From: Farhad Khatibi
Sent: 04 February 2026 17:50
To: Planning ContactCentre
Cc: Rupert Roberts
Subject: RE: Attached letter from Kirklees Council regarding application number 2025/92088 at location Land off, Bankwood Way, Birstall Retail Park, Birstall, Batley, WF17 9DT

Further to a review of the latest revised information submitted in connection with the above, I would like to advise that there are two new retaining structures supporting Woodhead Road at the above, and the current status in relation to their technical approval is as follows:

Scale: AS SHOWN	Page Size: A1	Status: TENDER
Drawn by: AC	Date: JULY 2025	Checked: SM
Project No: 24185-SDS-00-XX-DR-C-3050		
Revision: T2

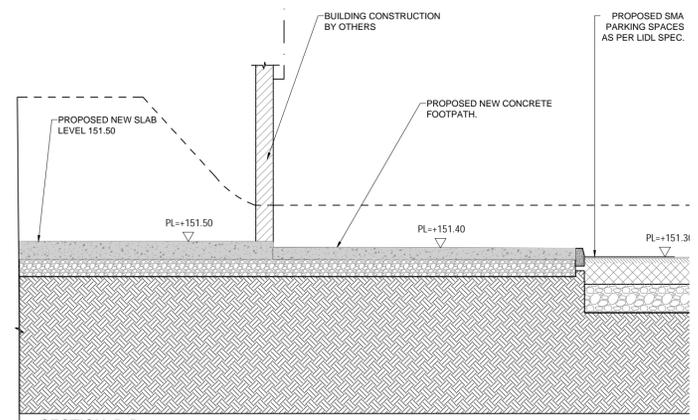
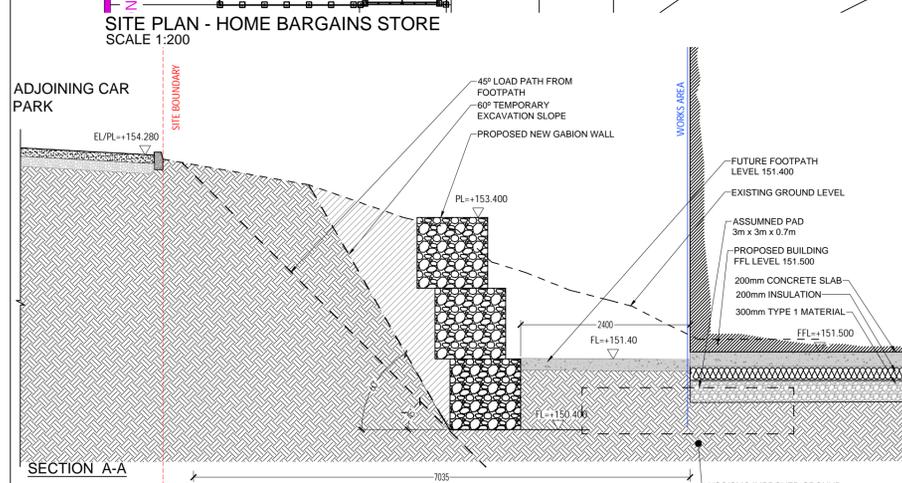
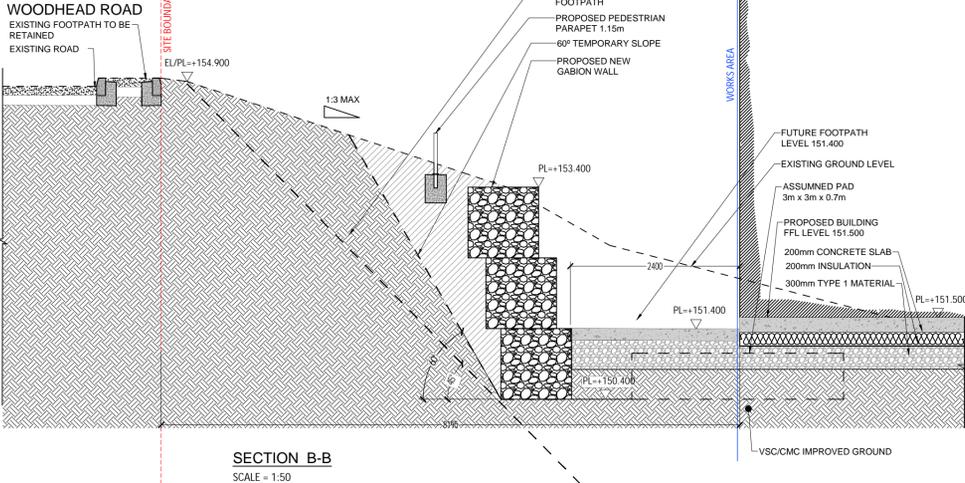
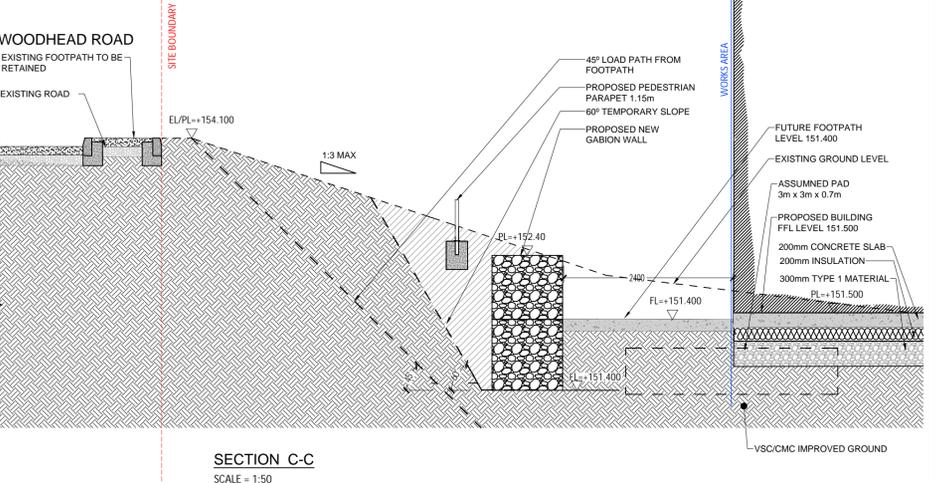
Piled Retaining Wall (Ref K61069A) adjacent to the Lidl Supermarket- The AIP for the design of this wall was conditionally agreed in August 2022, subject to the submission of satisfactory structural calculations together with a Design & Check Certificate (Category 2) for this structure, which remain outstanding. In addition, they will also need to submit a “Compliance Construction Certificate” together with “As Built” drawings in accordance with CG 300 following the completion of the works in order to conclude the technical approval process.

**AS BUILT DRAWING**

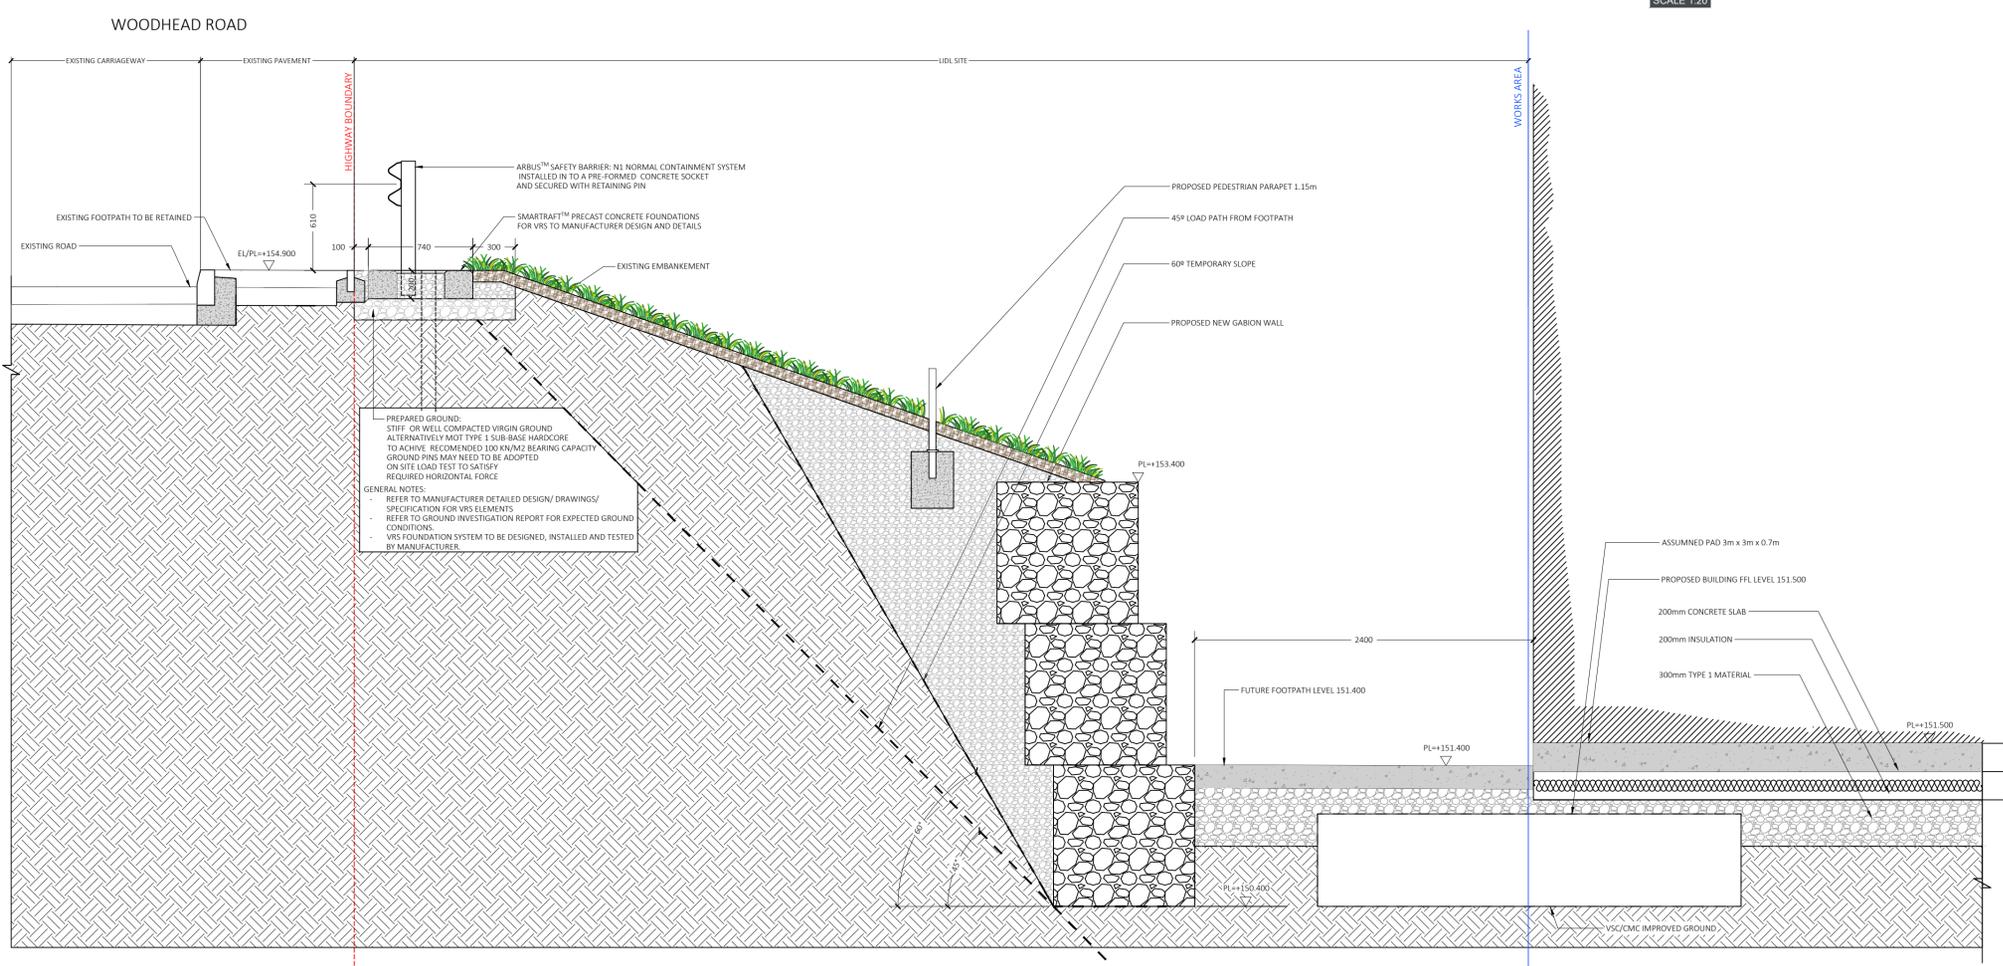
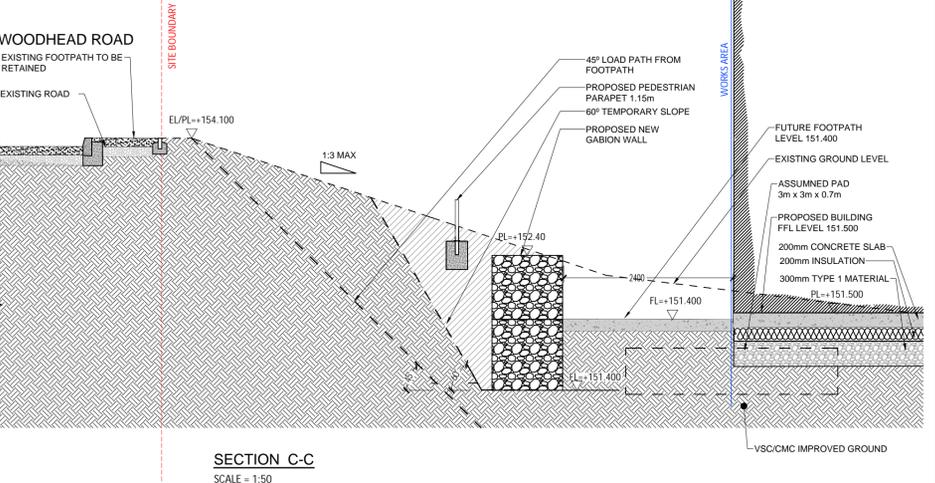
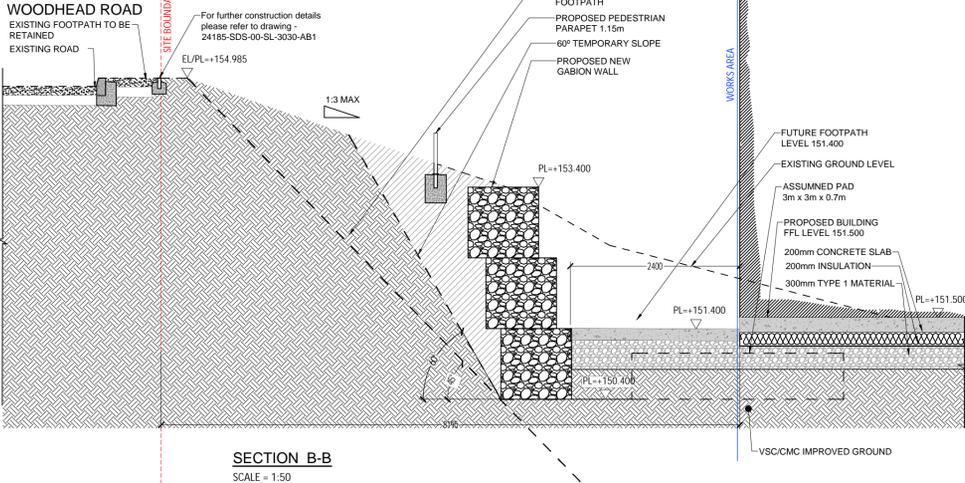
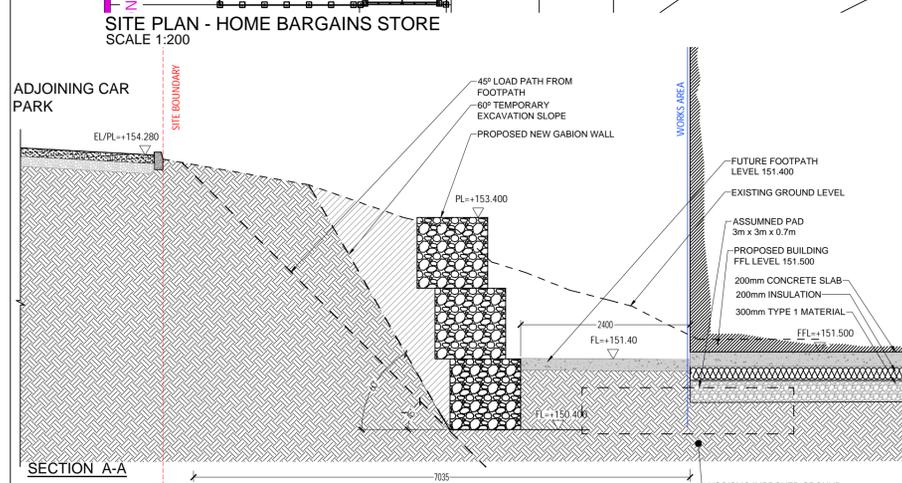
Modifications to the existing embankment (Ref K61069B) adjacent to the Starbuck & KFC- The latest submitted “As built” drawings are satisfactory, however, the “Construction Compliance Certificate” for this structure remains outstanding.
